Your Ref: OWPC5729
Our Ref: R/97/15/HH 16-04-2015
Please ask for:
Mr D Easton

Single storey side extension to create kitchen/family room & additional bedroom. Porch extension to front of property
14 Hawke Close Rustington

Side Elevation (north)

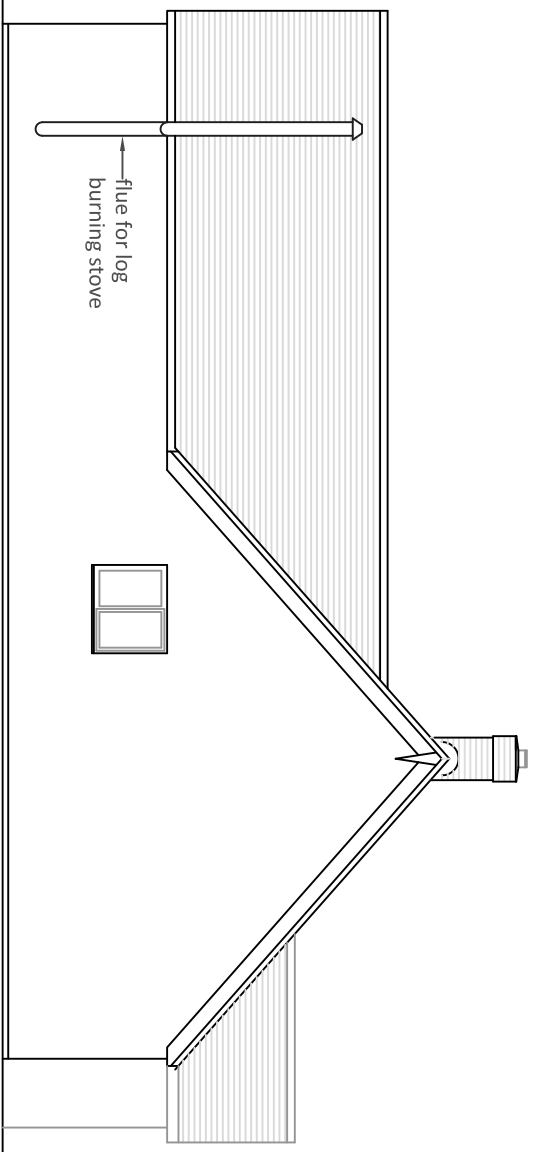
No objection in principle but would appreciate a condition in any planning permission granted that no windows, in particular dormers, are permitted at first floor level/ in the roof space in the northern elevation since this would overlook the garden and adversely affect the amenity of number 12 Hawke Close. Thank you.
